A303 Stonehenge: Amesbury to Berwick Down

Written Representations

Morrison and King Limited - A Tier 1 Landowner and Agricultural Tenant

May 2019

APPENDIX THREE - ILLUSTRATIVE PLANS OF PROPOSED COMPOUND

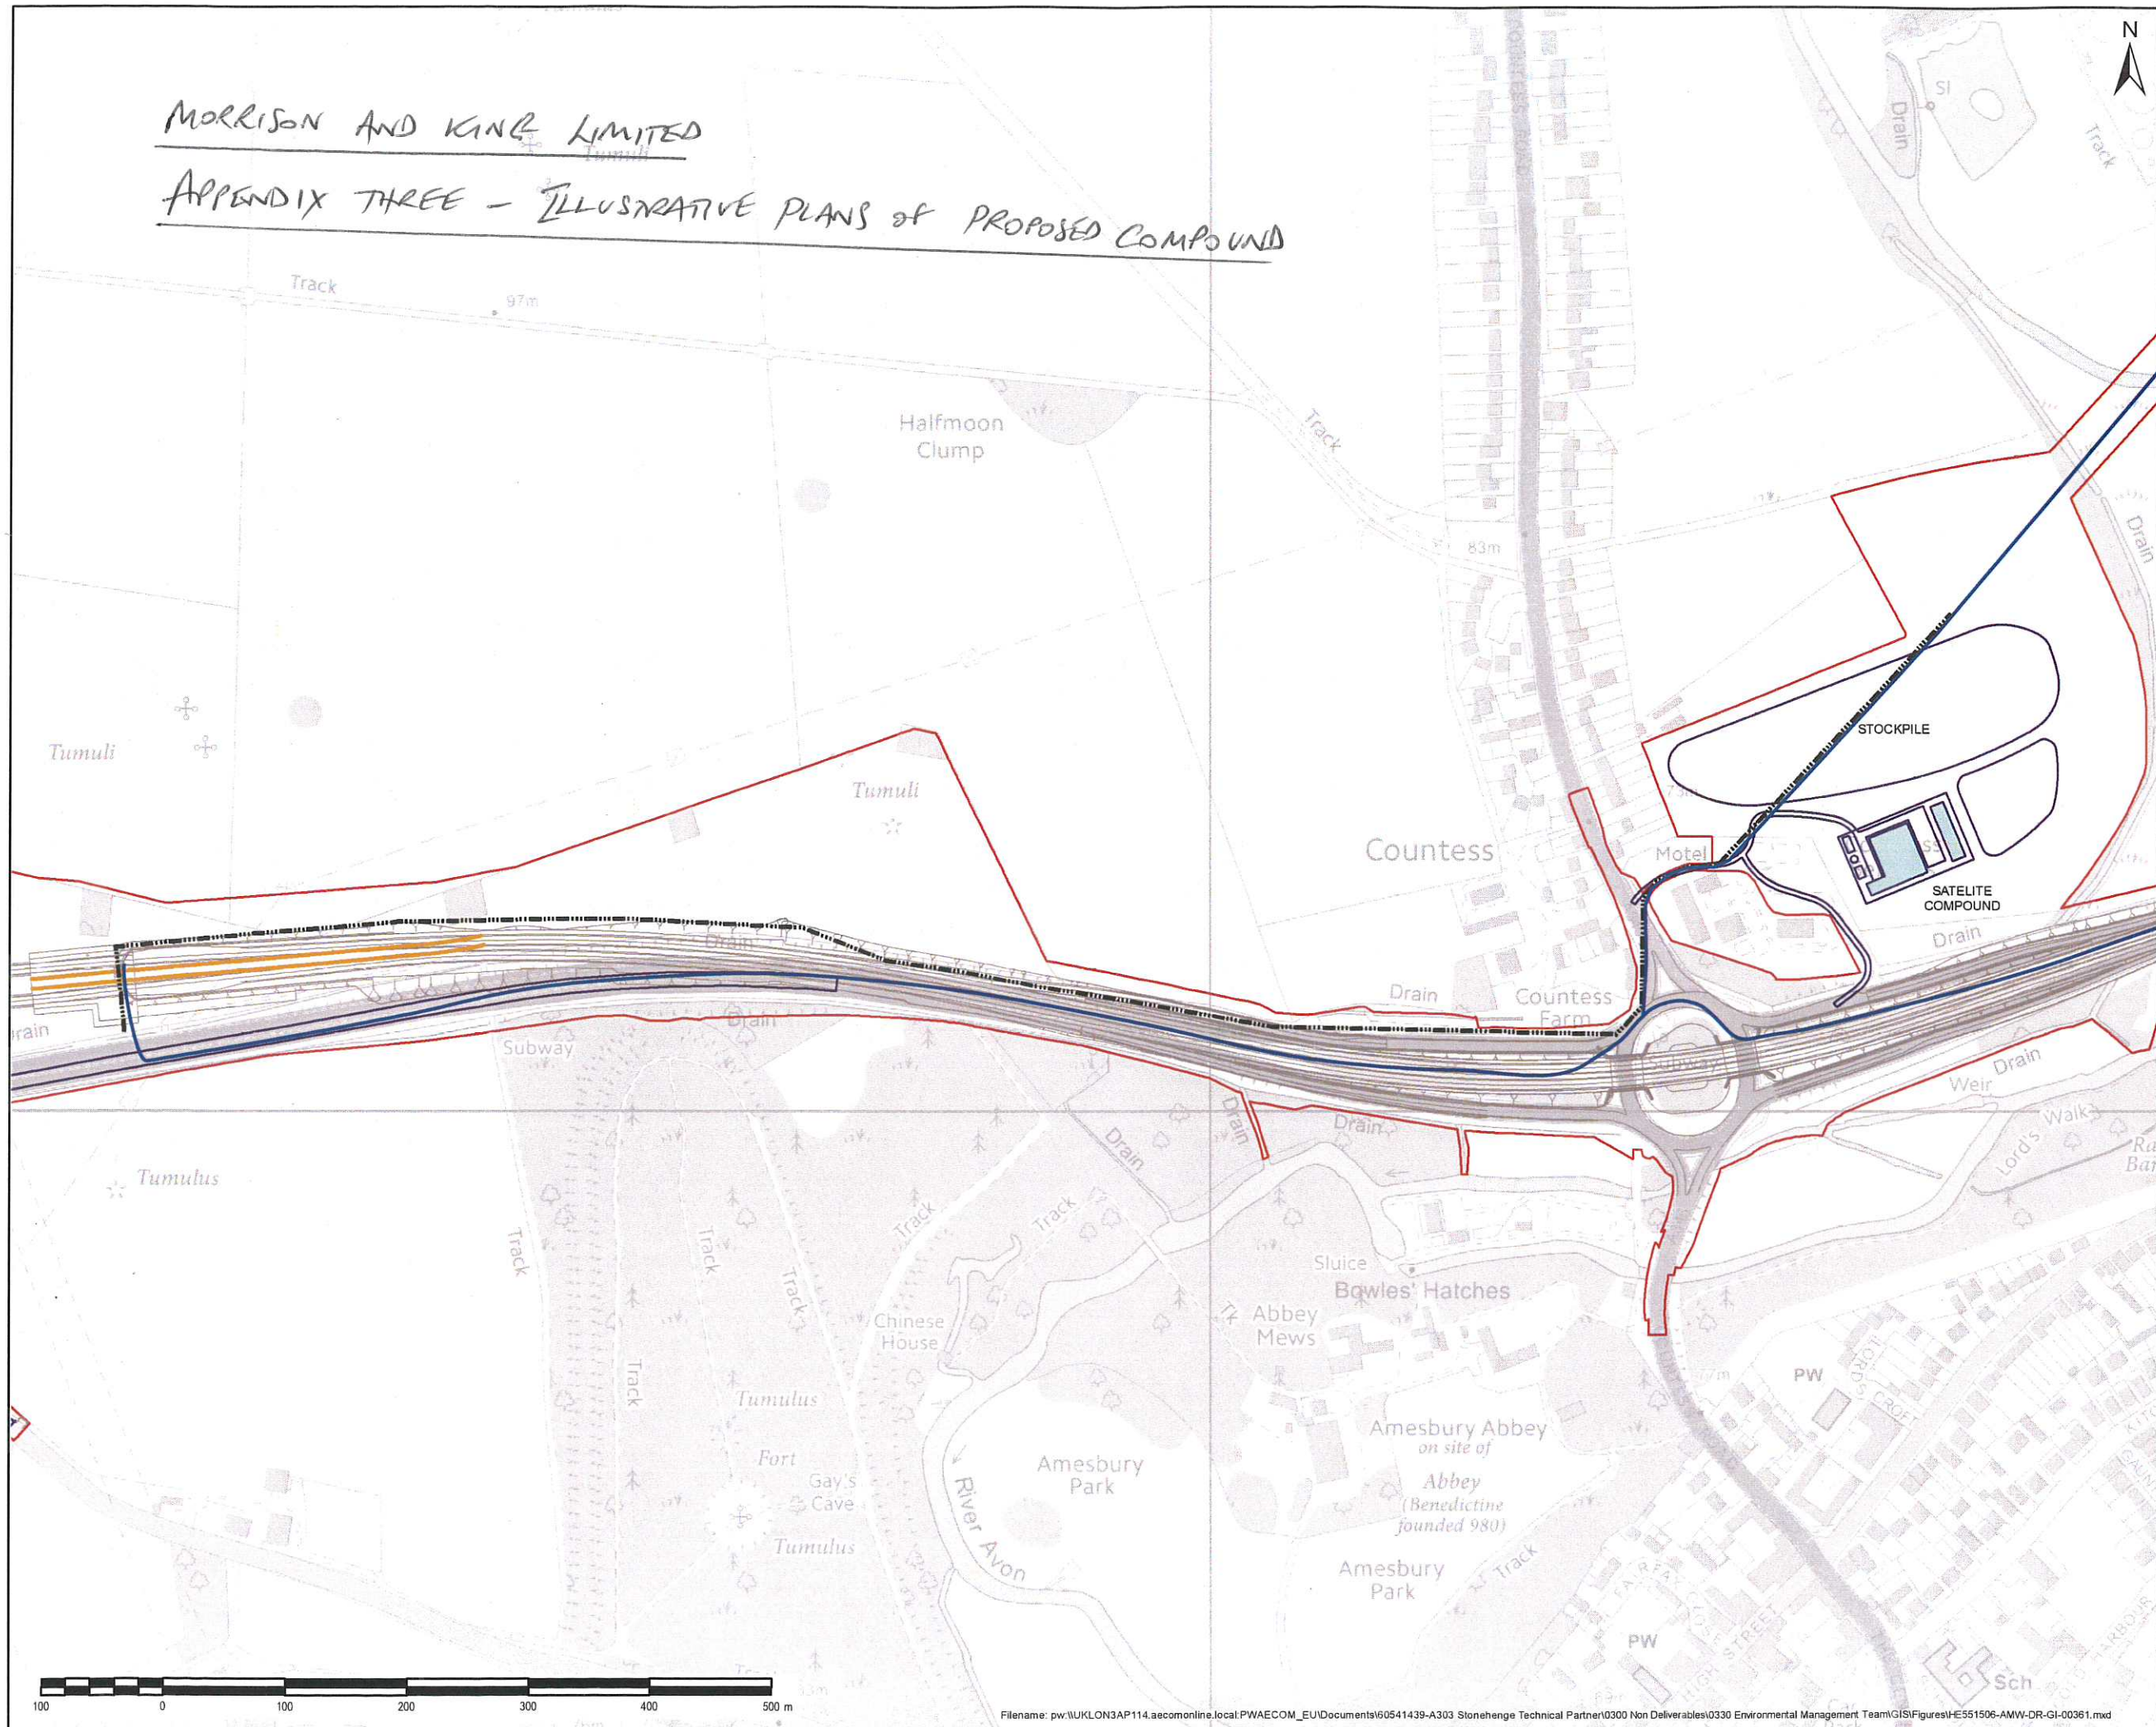
- 3.1. The level of detail provided by the Applicant relating to the proposed site compound on MKL's freehold has been woefully inadequate. Virtually the full extent of this is contained within the illustrative layout attached within Appendix Three. The self-same document raises more questions than it answers:

- 3.1.1. If there are to be extensive offices as shown where is the parking provision or are all workers expected to arrive by public transport?
 - 3.1.2. This illustrative layout has been prepared to the same scale as the main compound within the same Appendix and this merely serves to underscore the vast scale of the stockpiles shown within the proposed site compound, estimated to cover in excess of nine acres. No explanation as to what these stockpiles will consist of has been forthcoming despite repeated enquiries of the Applicant. It seems almost inconceivable that an engineering project is proposing nine acres to be compulsory acquired for stockpiling and yet the detail of what is to be stockpiled is not available.

- 3.1.4. The illustrative layout referred to above shows a new water main being installed across the site; a site that is known to have archaeological interest. When questioned over this water main the Applicant explained that this was to be a water supply to the tunnel/main compound and it was therefore suggested that a better route might be found; one that did not require a crossing of the River Avon nor an area of known archaeological interest. It was subsequently revealed that this supply was for the proposed site compound on MKL's freehold and not the tunnel/main compound whatsoever, contrary to the detail within the illustrative layout. Surely as simpler and less disruptive supply could be taken from the main within Countess Road for that purpose?

- 3.4. It has hopefully been made clear that the current level of detail regarding the proposed site compound is woefully inadequate to enable reasoned judgements and representations to be made. The most worrying of all being that when repeated enquires have been made of the Applicant regarding further necessary detailed information the stock reply has been that such information '*will be determined by the appointed contractor*' and '*produced prior to works commencing*'.

APPENDIX FOUR - LOCATION OF LIVELY STABLES

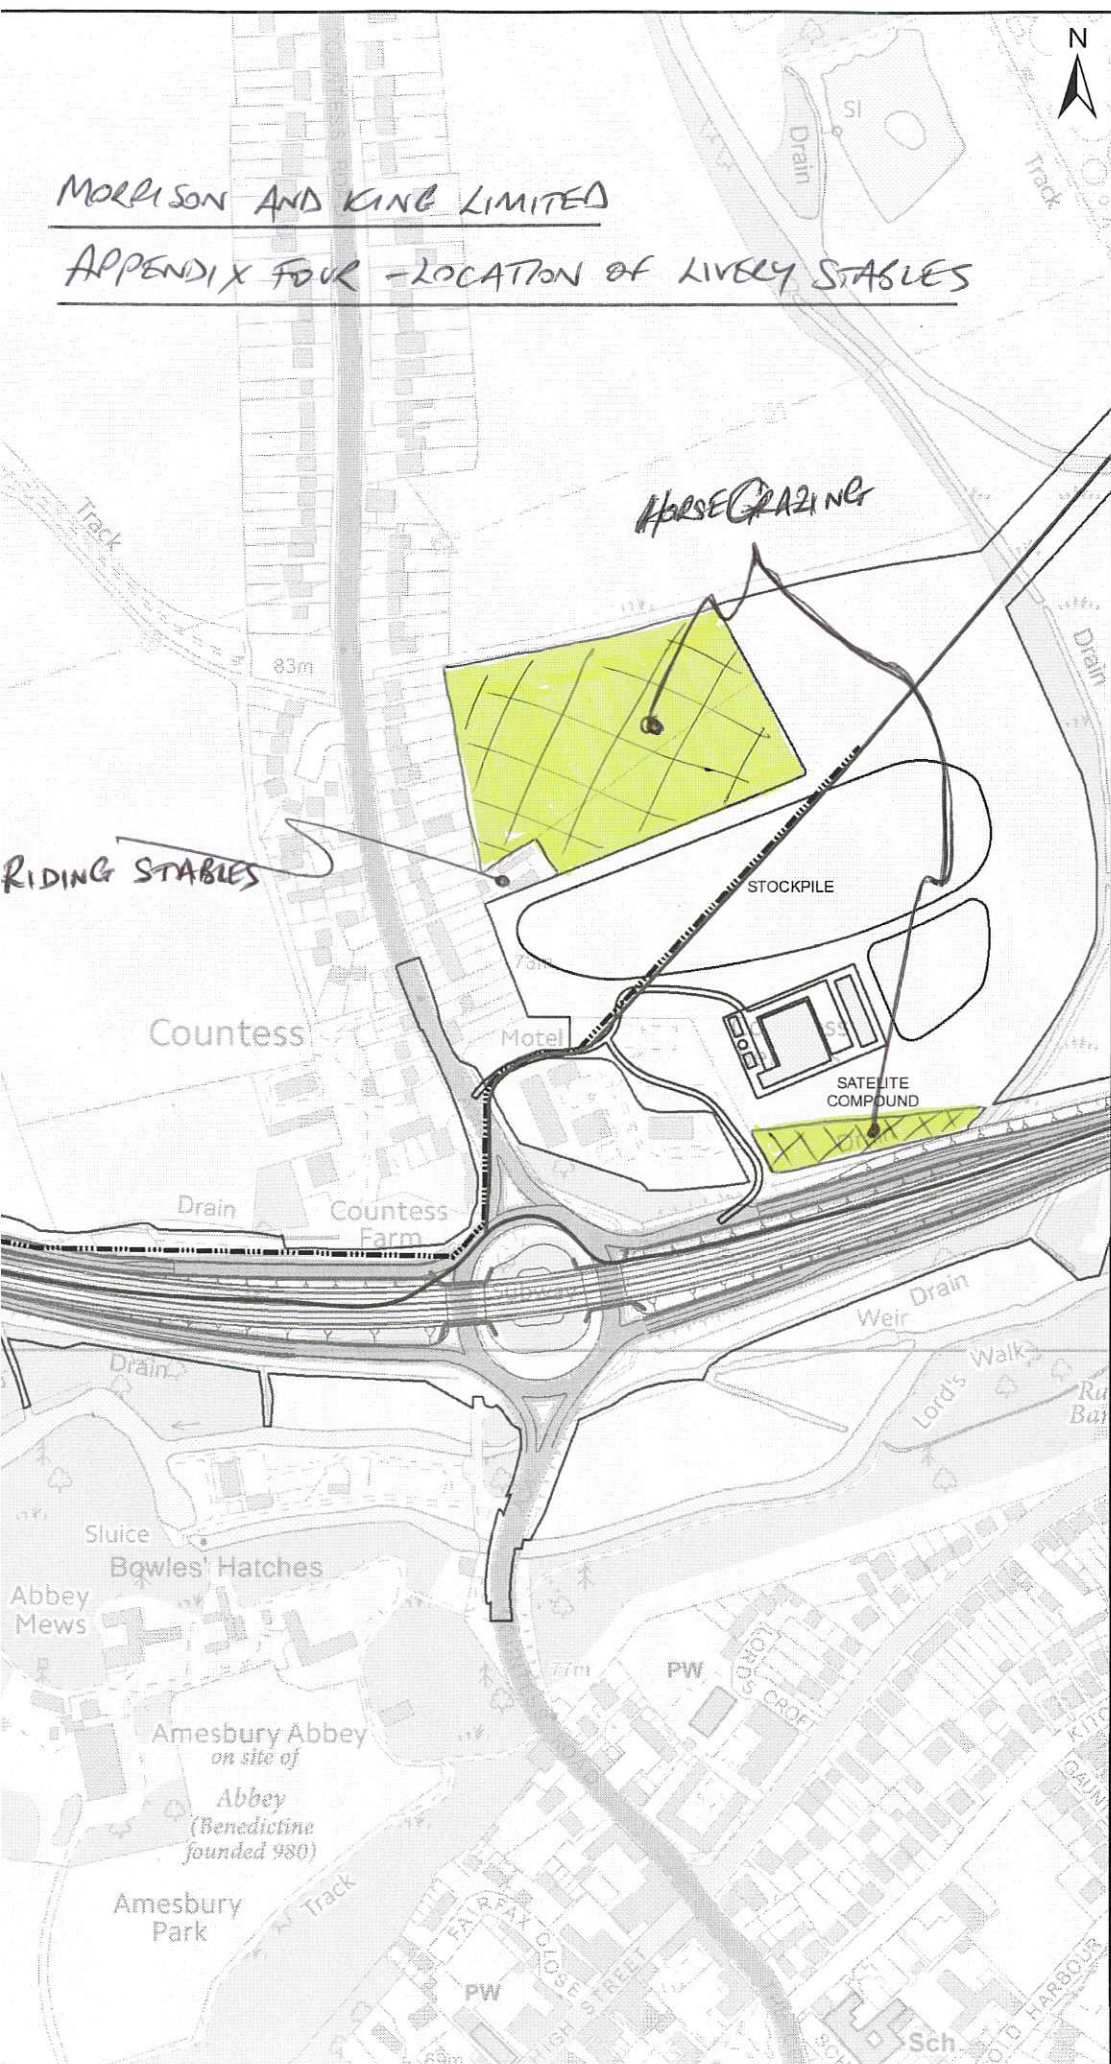
- 4.1. MKL has diversified its agricultural business by operating a horse livery enterprise out of a stable yard identified on the plan attached as Appendix Four. The stable yard consists of stables for a maximum of eight horses and an associated manège. The livery business utilises the grassland identified on the same plan. MKL supplies home produced hay and straw to this enterprise.
- 4.2. MKL has significant concerns regarding the likely disturbance to this enterprise arising from the Scheme. These concerns are fourfold as detailed below and insufficient detail has been provided by the Applicant to allay such concerns.

The location of the site compound immediately adjacent to the stable yard will undoubtedly lead to significantly increased levels of noise, dust and light intrusion. The Applicant has referenced the relevant topic chapters of the Environmental Statement, including Chapter 5, Air Quality (APP-043), Chapter 7 (APP-045), Landscape and Visual, Chapter 9 APP-047), Noise and Vibration, and Chapter 13 (APP-051), People and Communities (document reference 6.1). These assessments have concluded that there would be a range of adverse impacts during construction, presumably the entire period that the site compound is located adjacent to the stable yard.
